**Re: Innova Plaza South Building,  
401 Eubank Blvd. SE Albuquerque, NM  
Request for Certificate of Occupancy  
Transportation Development Final Inspection  
Engineer's/Architect's Stamp dated 03-03-2017 (L20D067)  
Certification dated 02-12-2018**

Based upon the information provided in your submittal received 11-21-2018, Transportation Development cannot approve the release of Certificate of Occupancy for the above referenced project.

INNOVA PLAZA - SITE DEVELOPMENT
OVERALL SITE PLAN
401 EUBANK SE, ALBUQUERQUE, NM 87123
PROJECT #1459

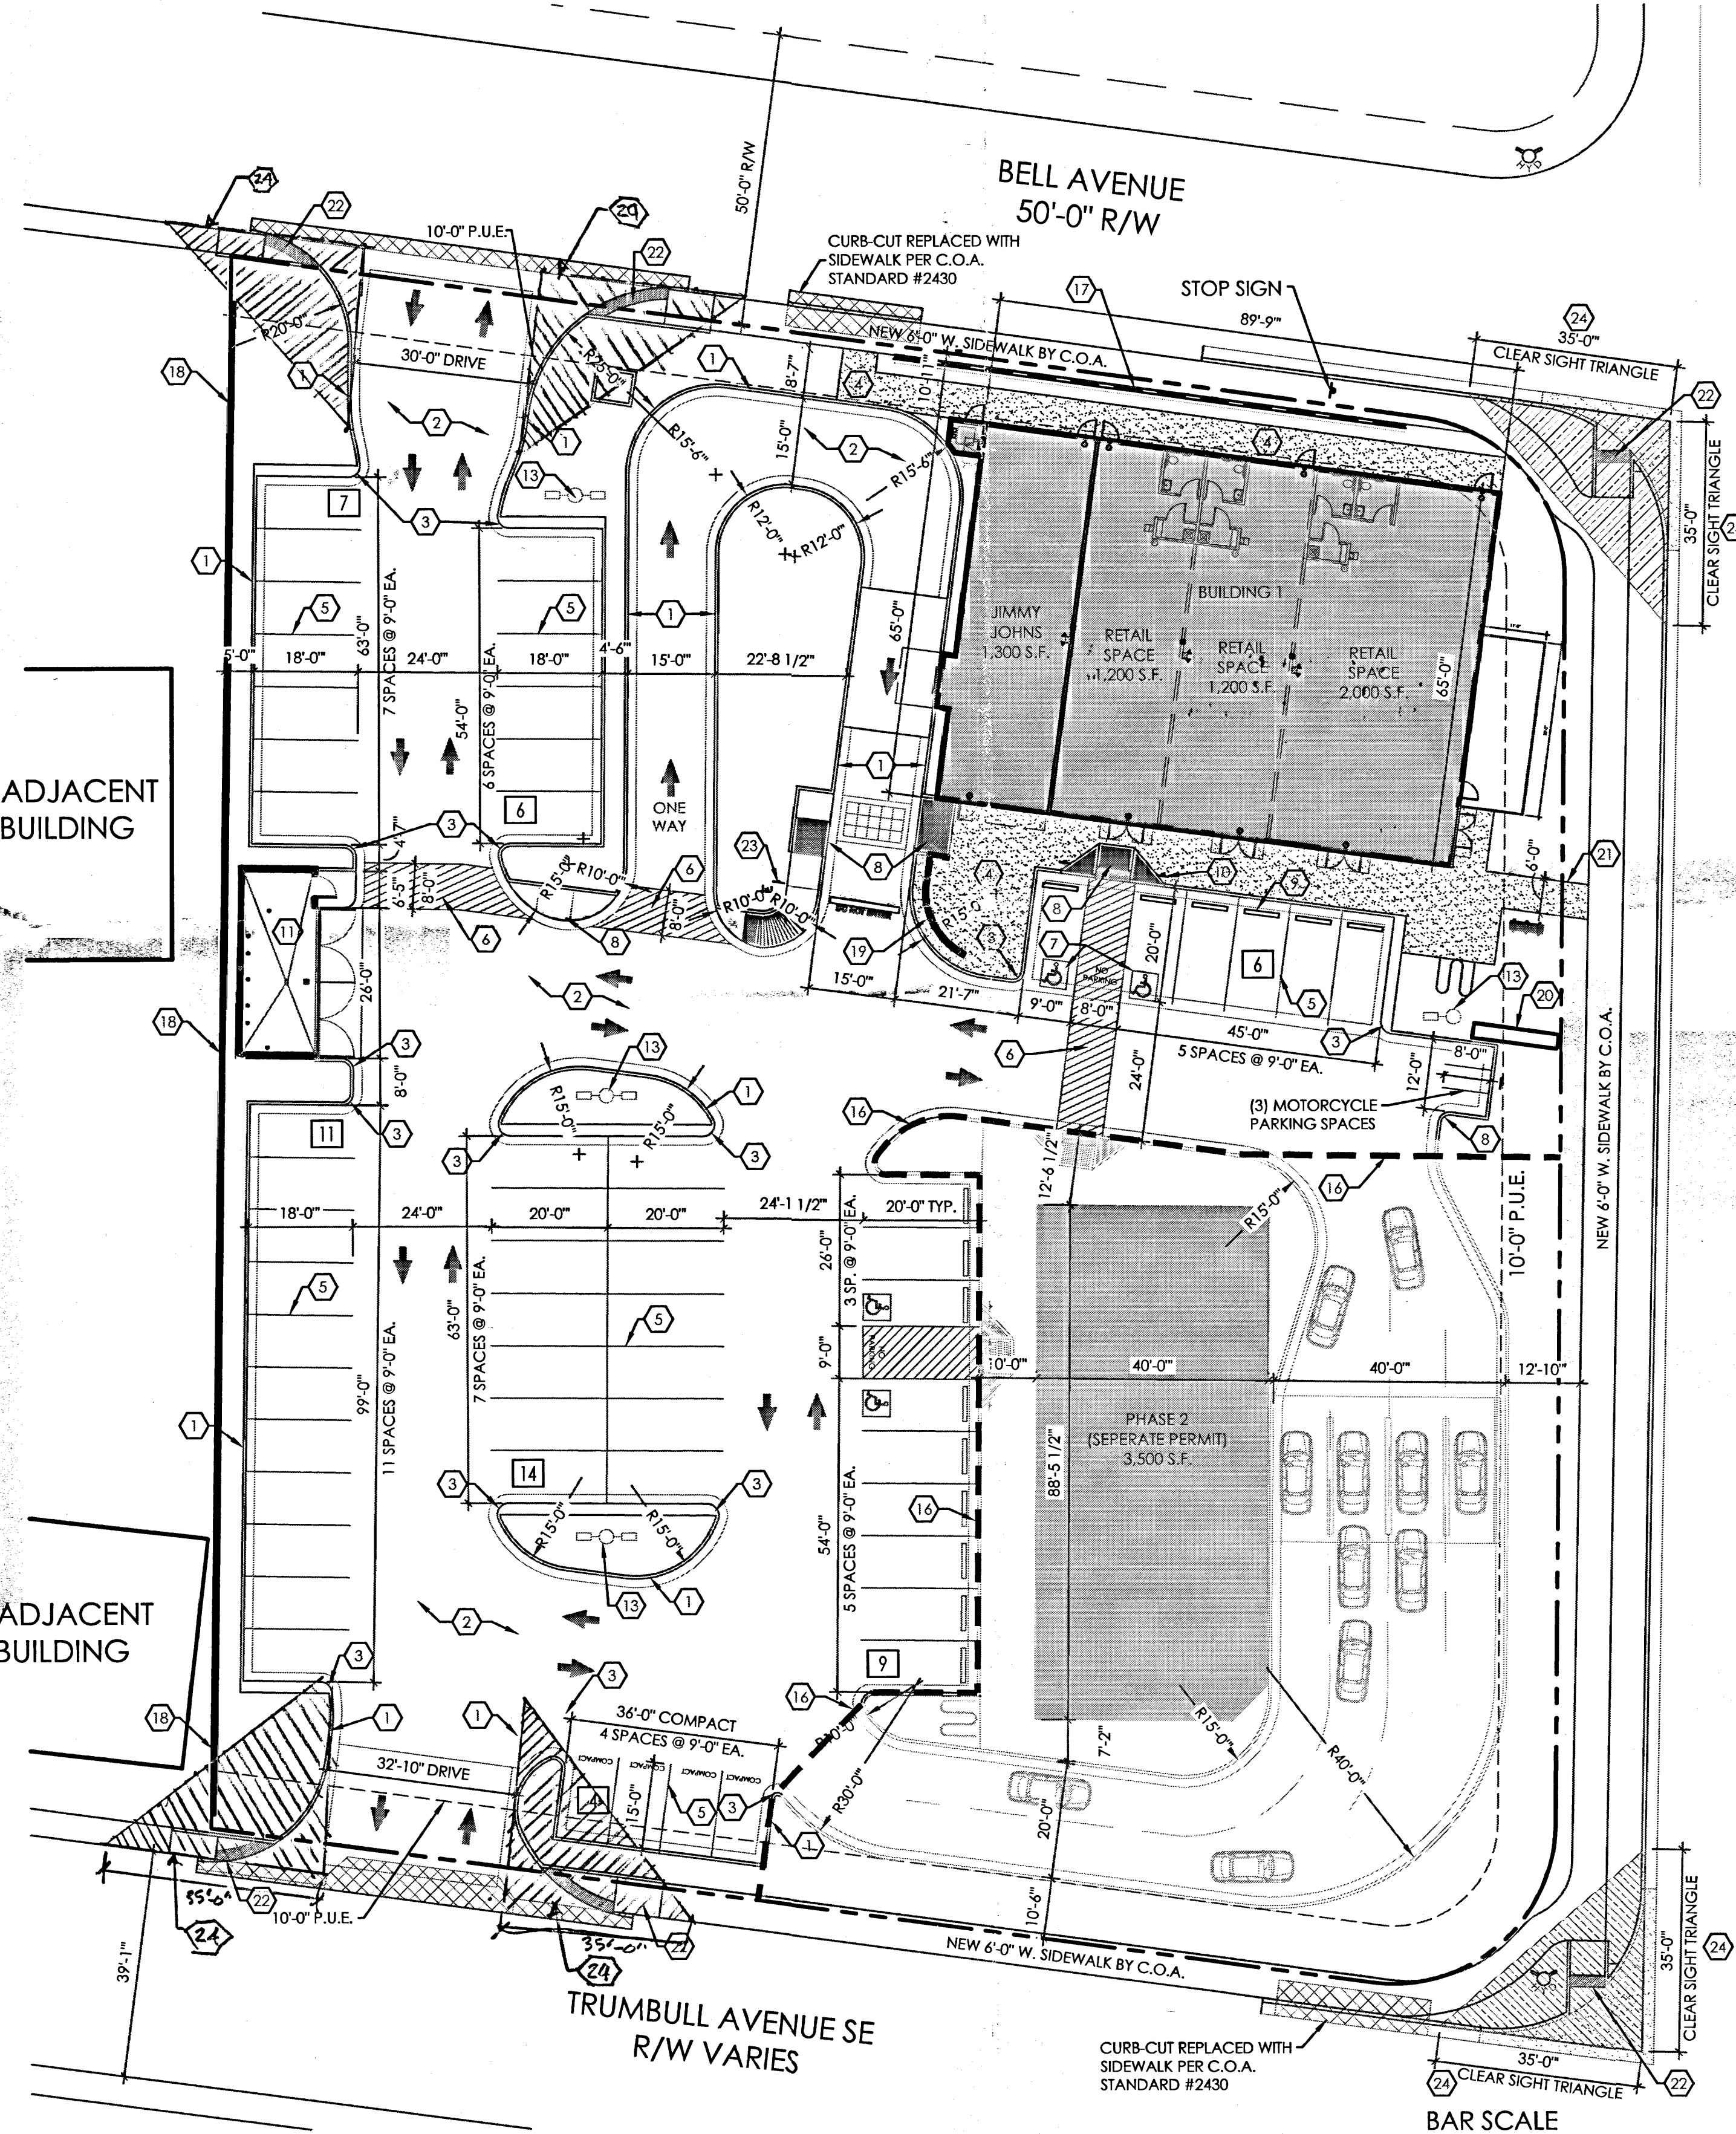
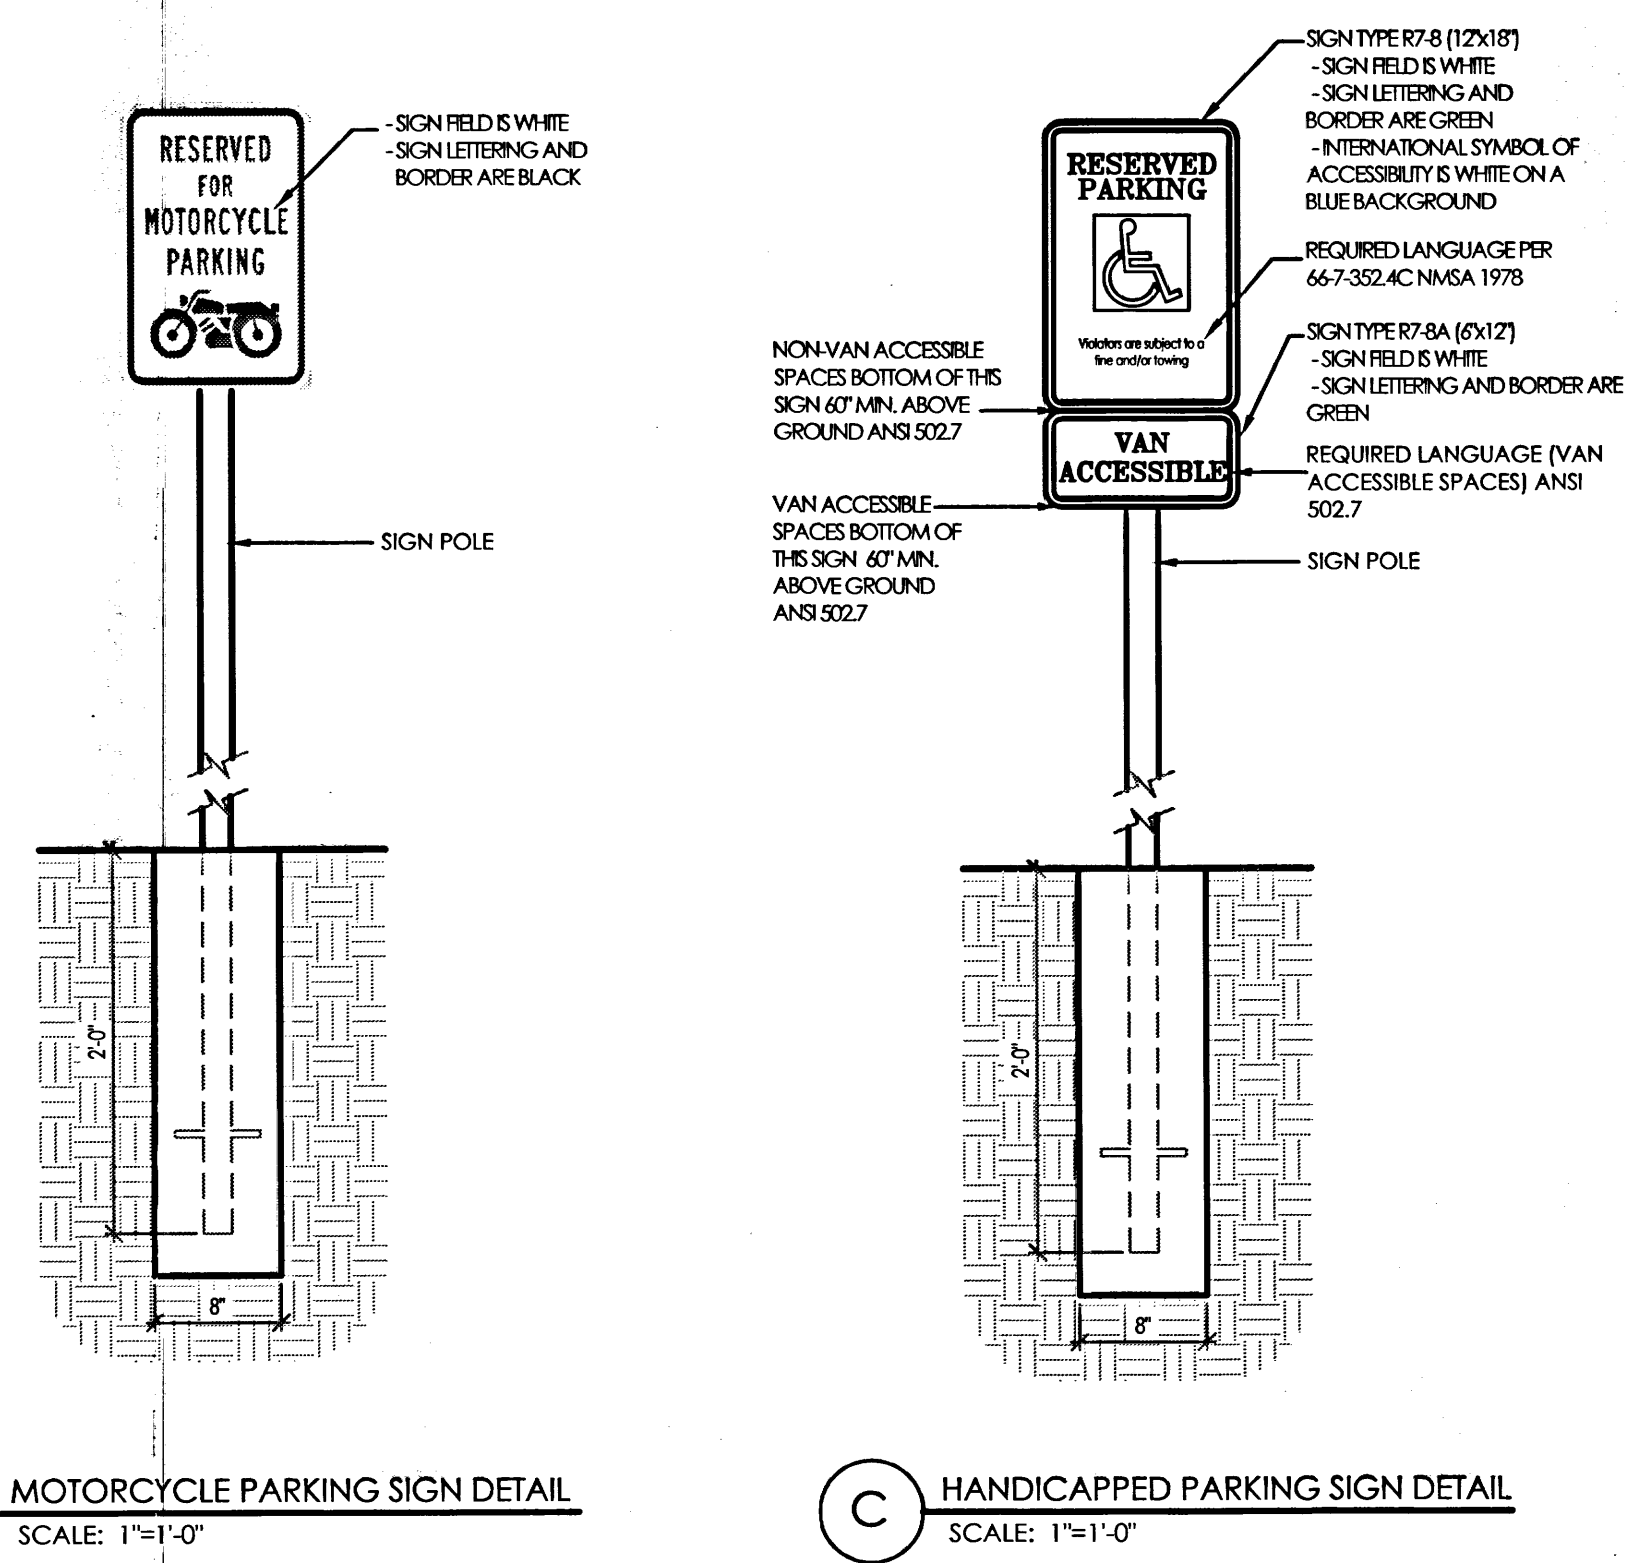
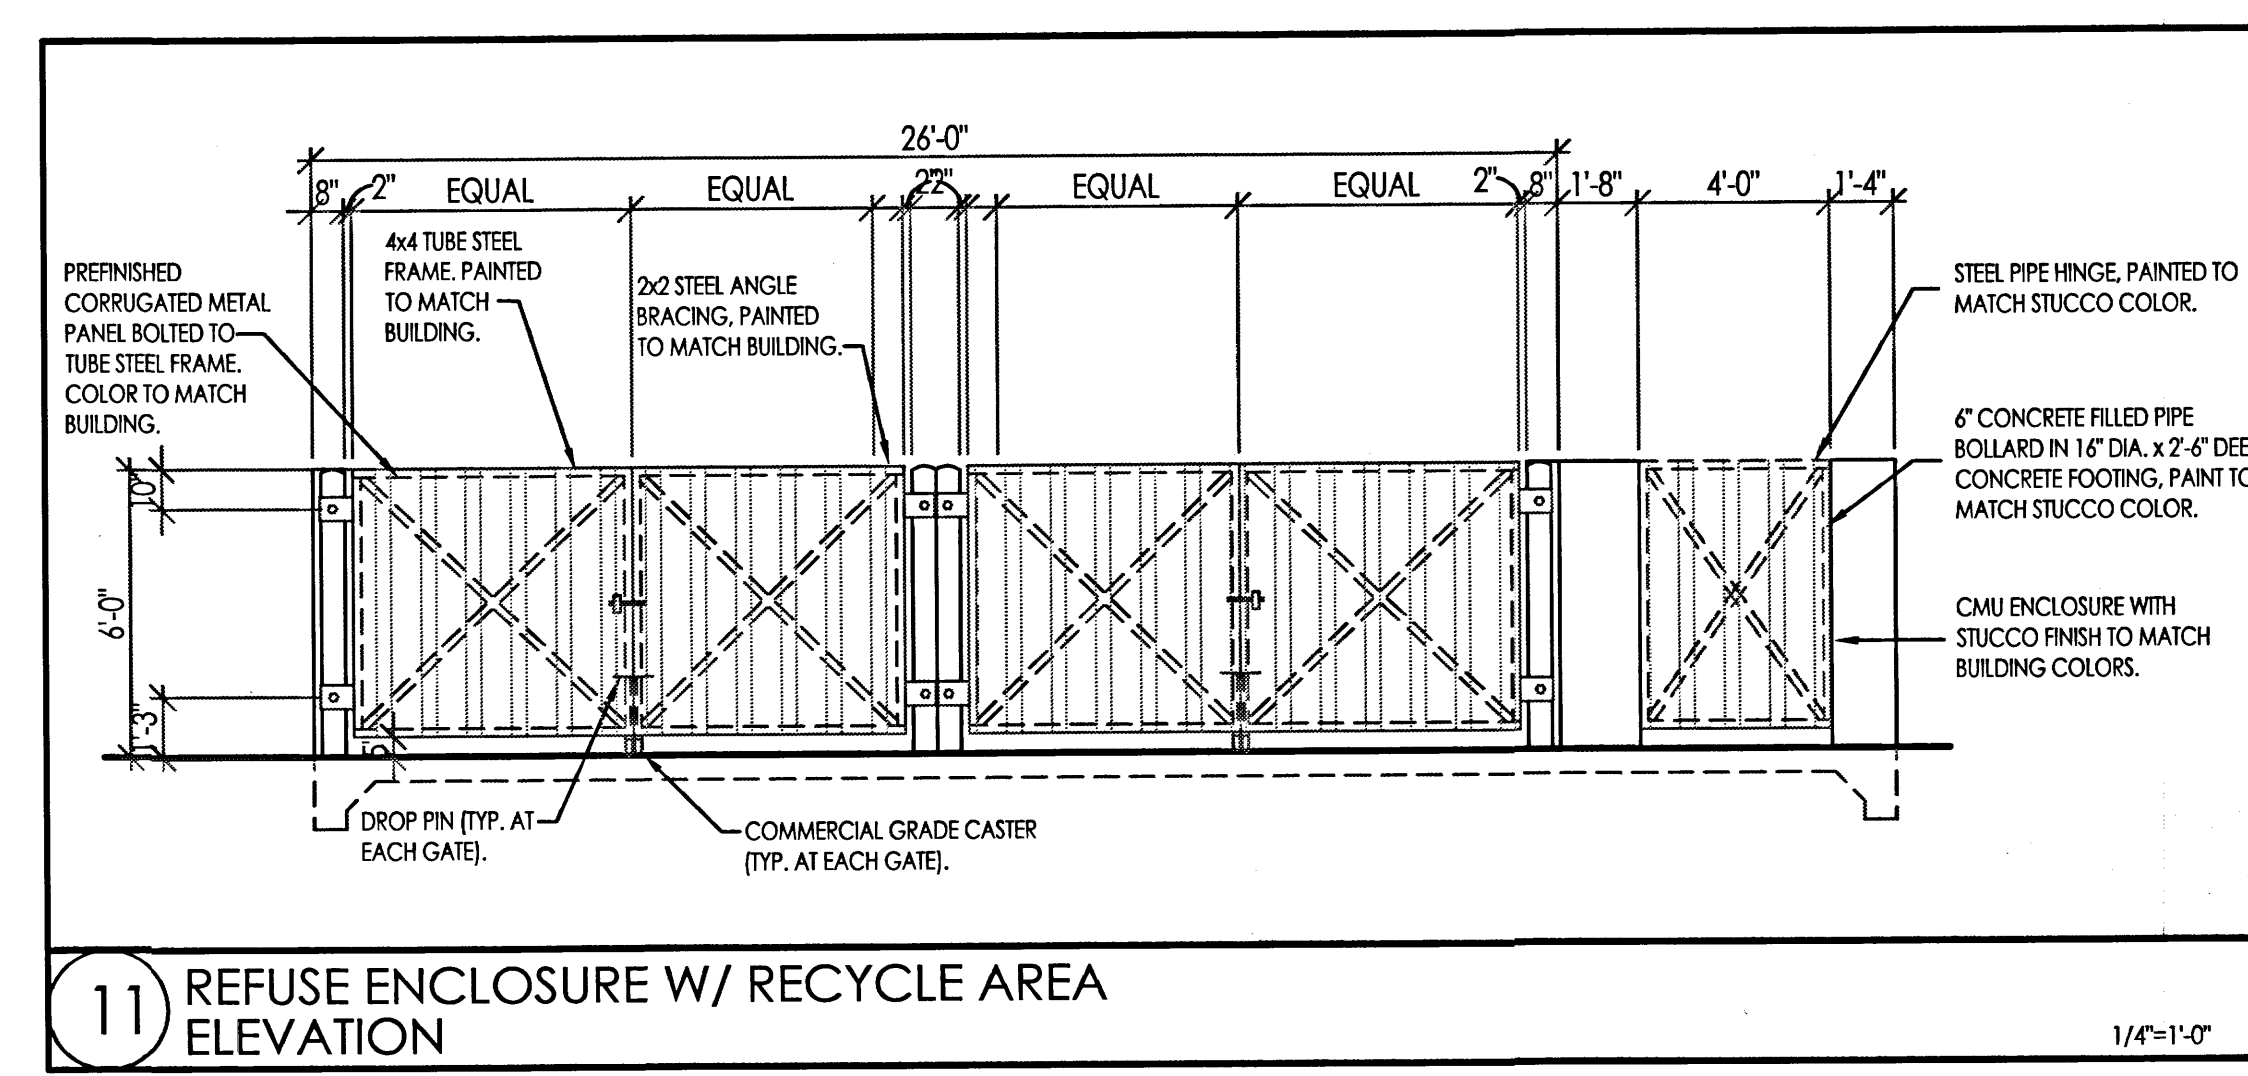
- Please clear the site of all the debris
- Please install a pedestrian access connecting the side walk to the building the same way it was approved in the original submittal on 03-14-2018.
- Please make sure all the striping are the same as the original submittals.
